CAWSTON PARISH COUNCIL – RESPONSE TO EXA’S FURTHER WRITTEN QUESTIONS FOR NORFOLK BOREAS DEADLINE 5

Cawston Parish Council

26th February 2020

CAWSTON HIGH STREET - INTERVENTION SCHEME  
Scale 1:500

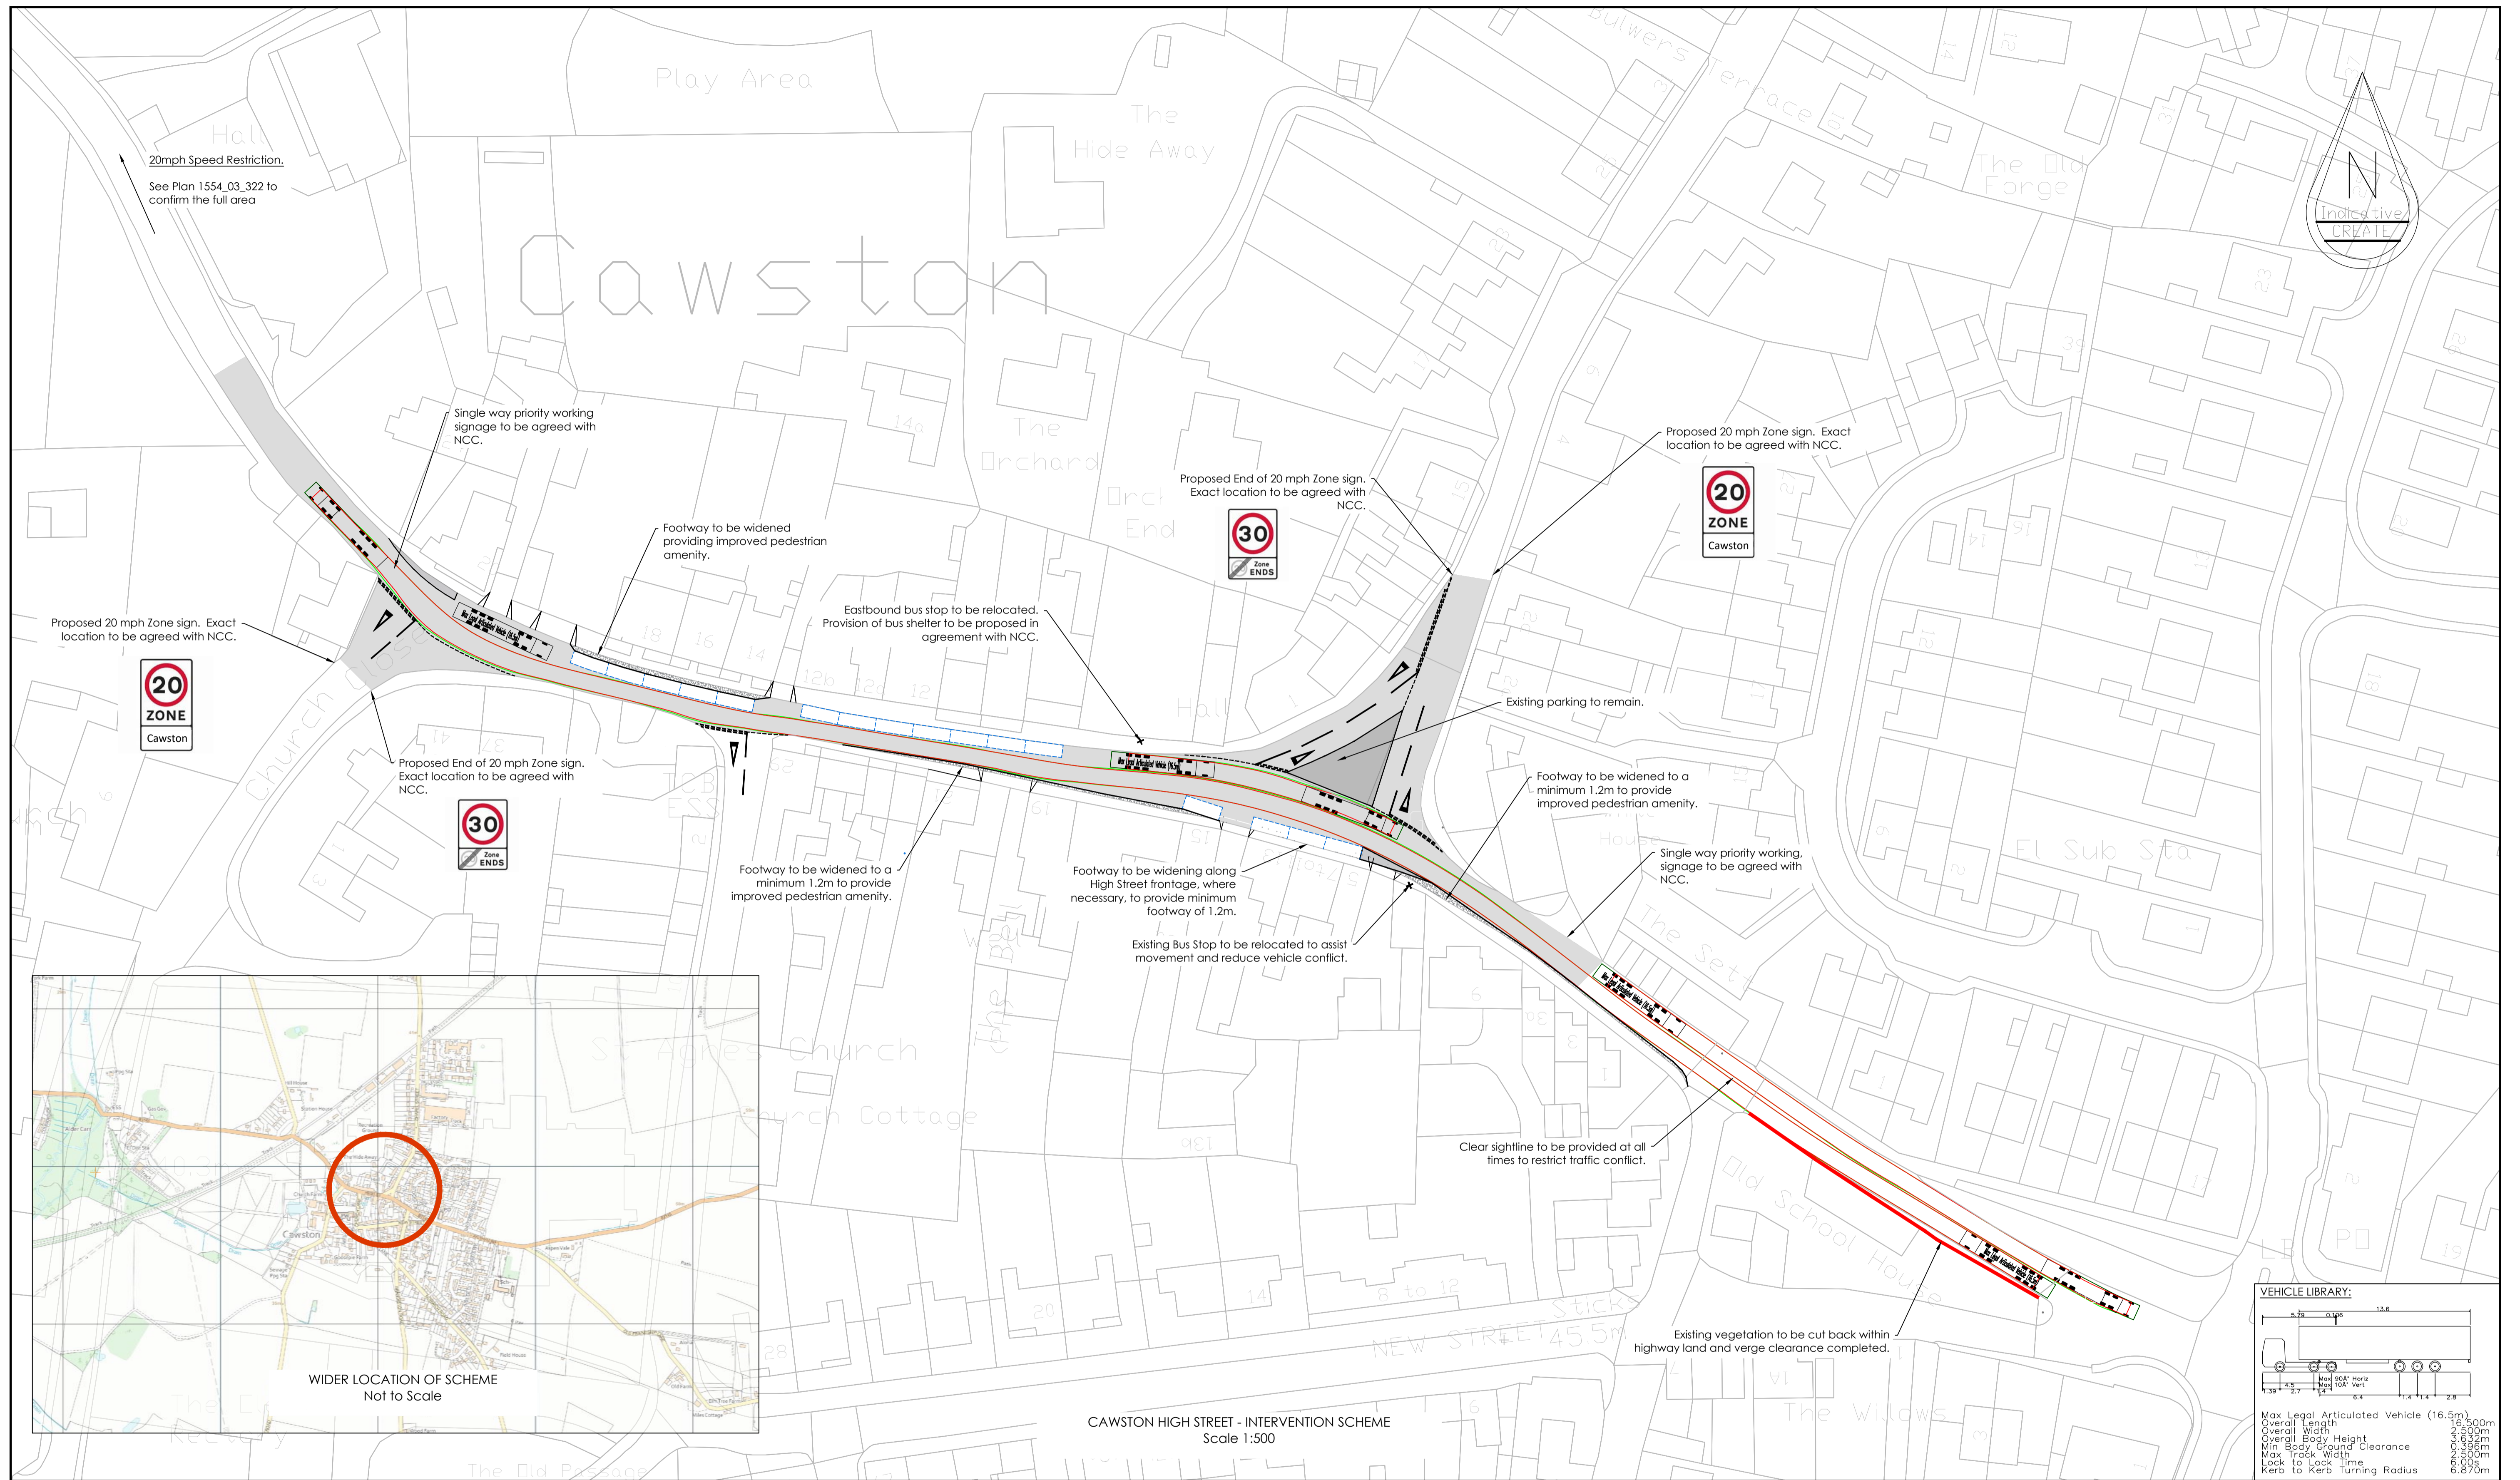
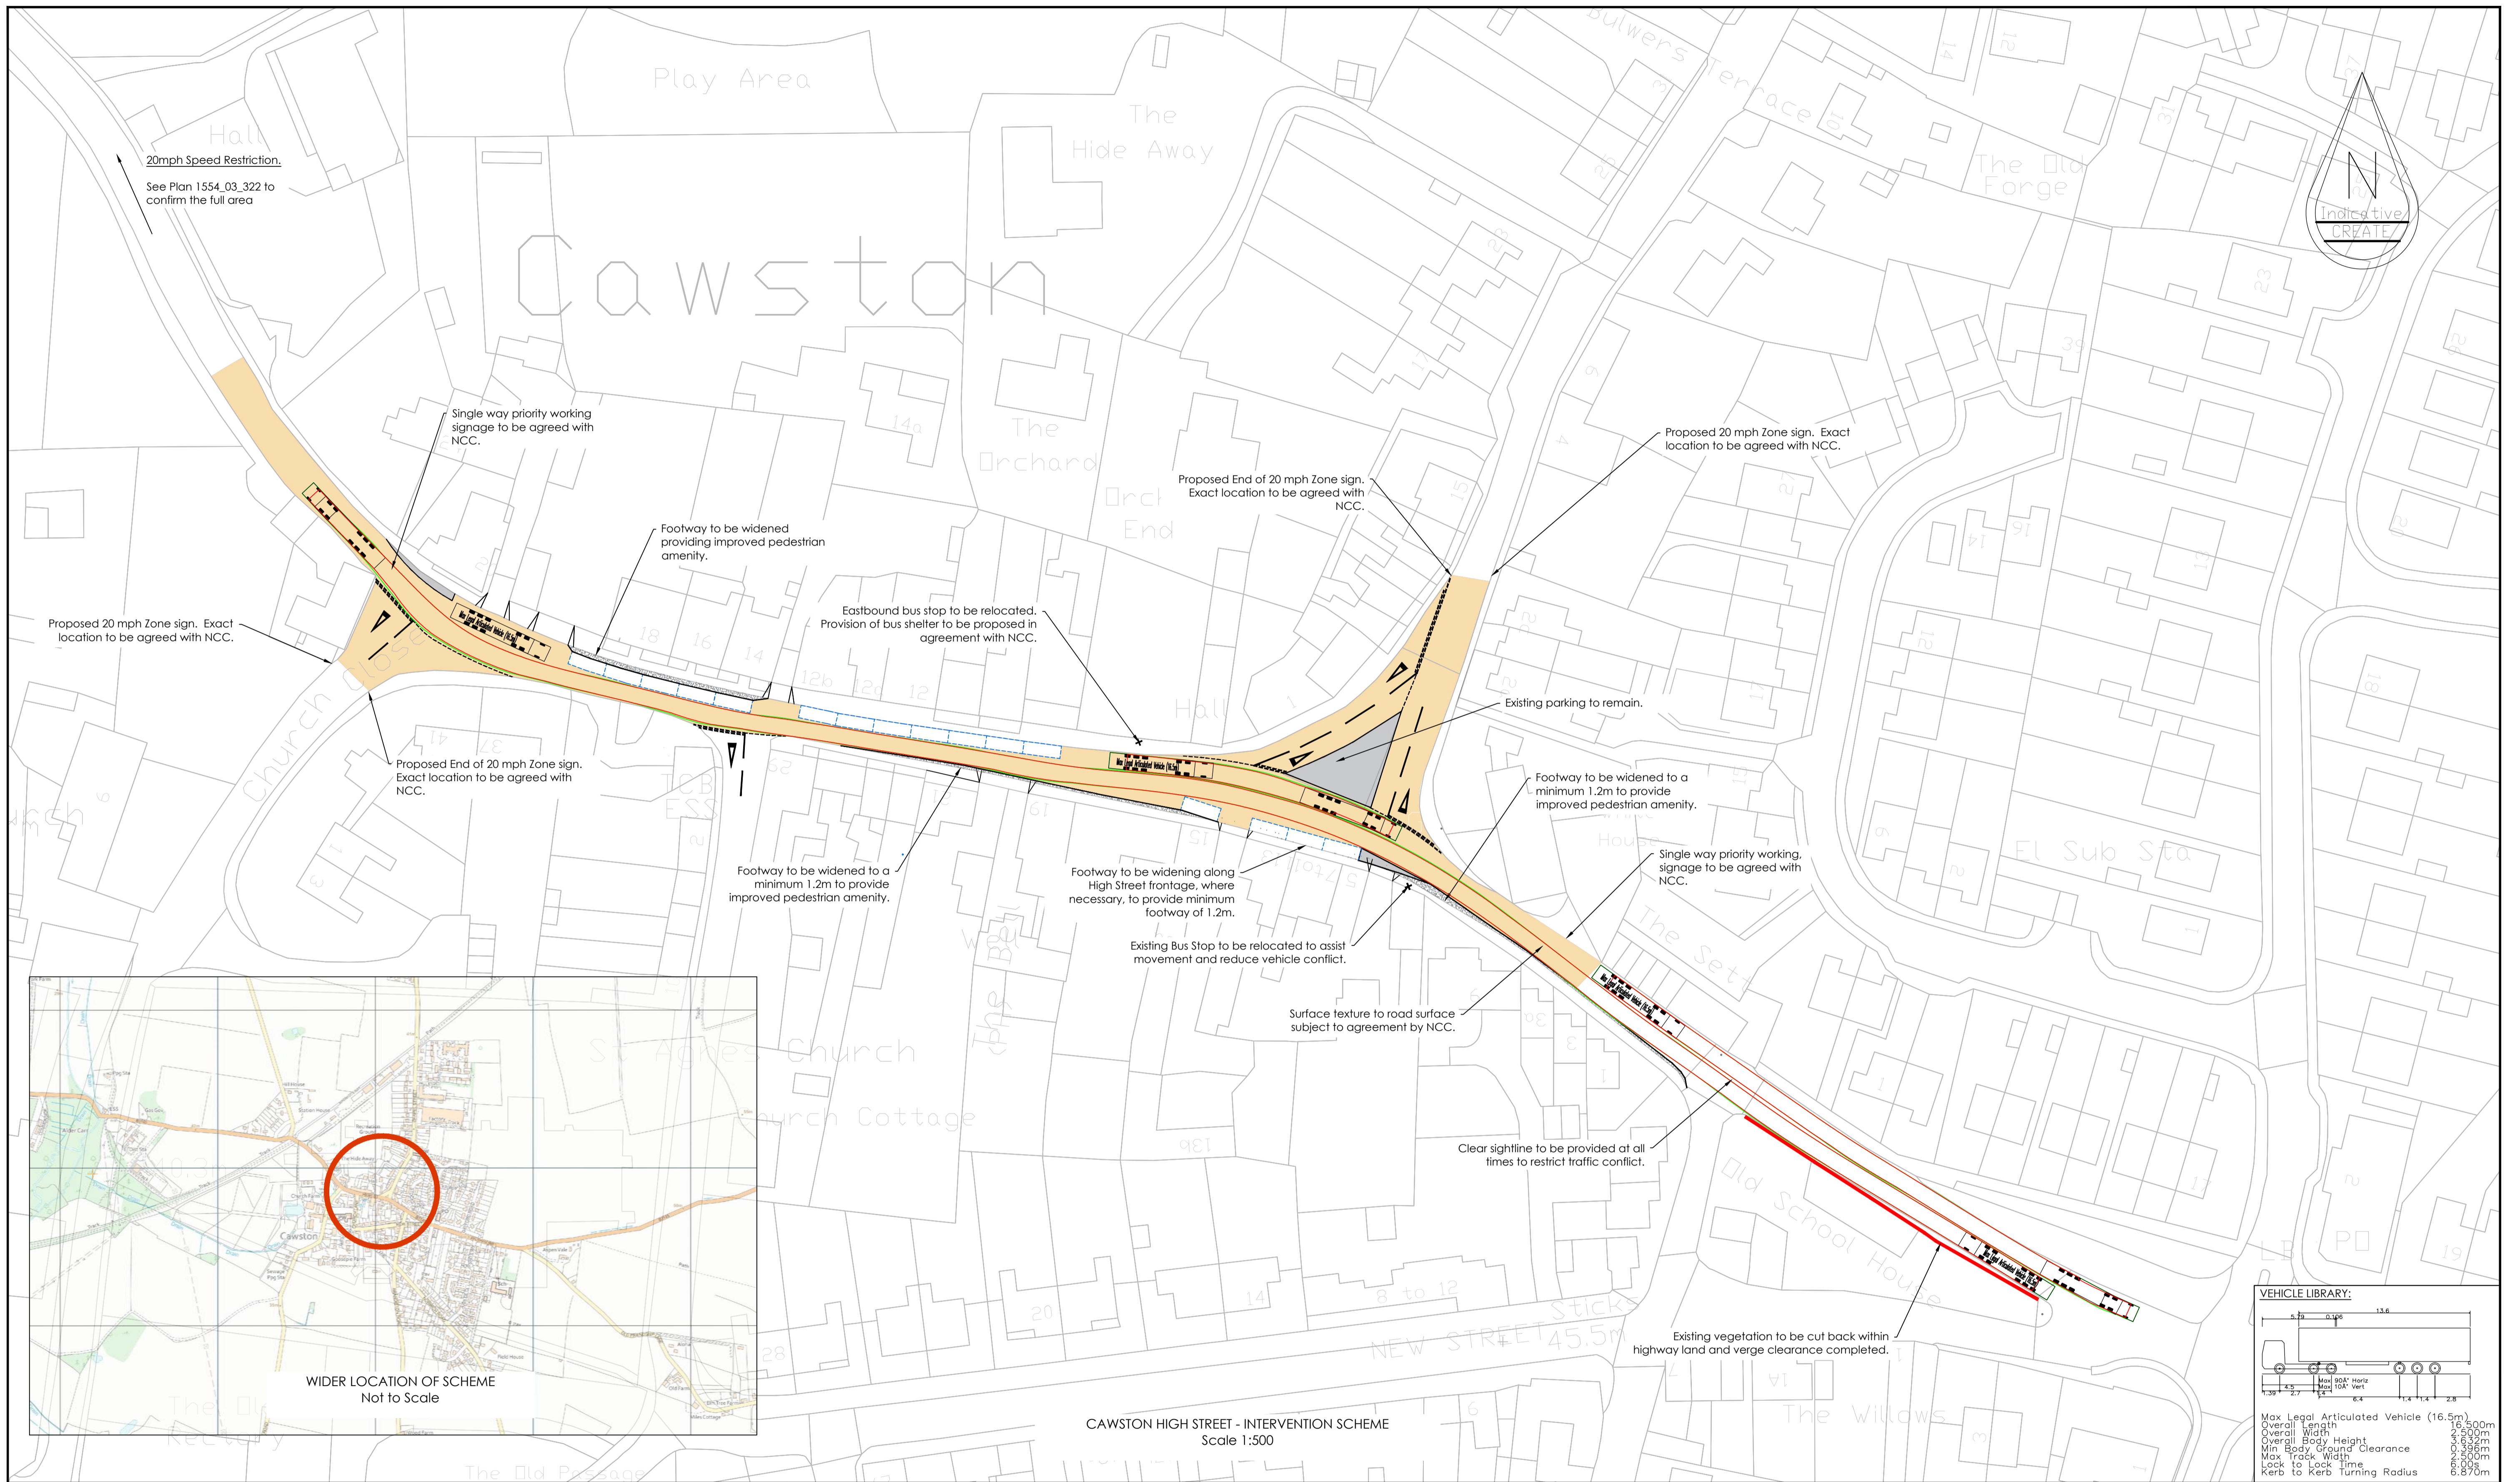
Due to the width of the road being too narrow in places for two large vehicles to pass safely it is inevitable that wing mirrors will overhang the pavement. Observation at the ASIs showed how common it is for larger vehicles actually to mount the pavement as well.

The latest version of the Highway Intervention Scheme removes features from previous versions which were claimed to improve pedestrian safety. It argues that "protection is afforded by parked vehicles", which suggests that pedestrians will be expected to scuttle from vehicle to vehicle like soldiers in a war movie! Woe betide the resident caught on the wrong side of the road, with only a yellow line to hide behind.

The scheme will also bring traffic closer to properties; the changes from the original H3 scheme are so wide ranging that we feel that previous assessments on Noise, Vibration and Air Quality (regardless of what you may think of their reliability) are now irrelevant. We consider that all these studies should be done again, independently, thoroughly and using up to date criteria, if ever a Scheme is accepted by NCC and passes a RSA.

As drawn in the HIS, vehicle tracks suggest the wheelbase of the vehicle is used as a measure of vehicle width. The potential impact of wing mirrors on pedestrians and passing traffic seems to be disregarded.

At the meeting the Applicants admitted that previous Highway Intervention Schemes had been based on OS mapping using inaccurate measurements. Apparently the latest Scheme is based on topographic data with accurate road measurements; even then it appears to use track width rather than the full width to indicate HGVs.

This is misleading as wing mirrors will add around 500mm to this width. We do not see why the residents of Cawston should be put at risk because of the lack of rigour in desk based modelling of the successive schemes.
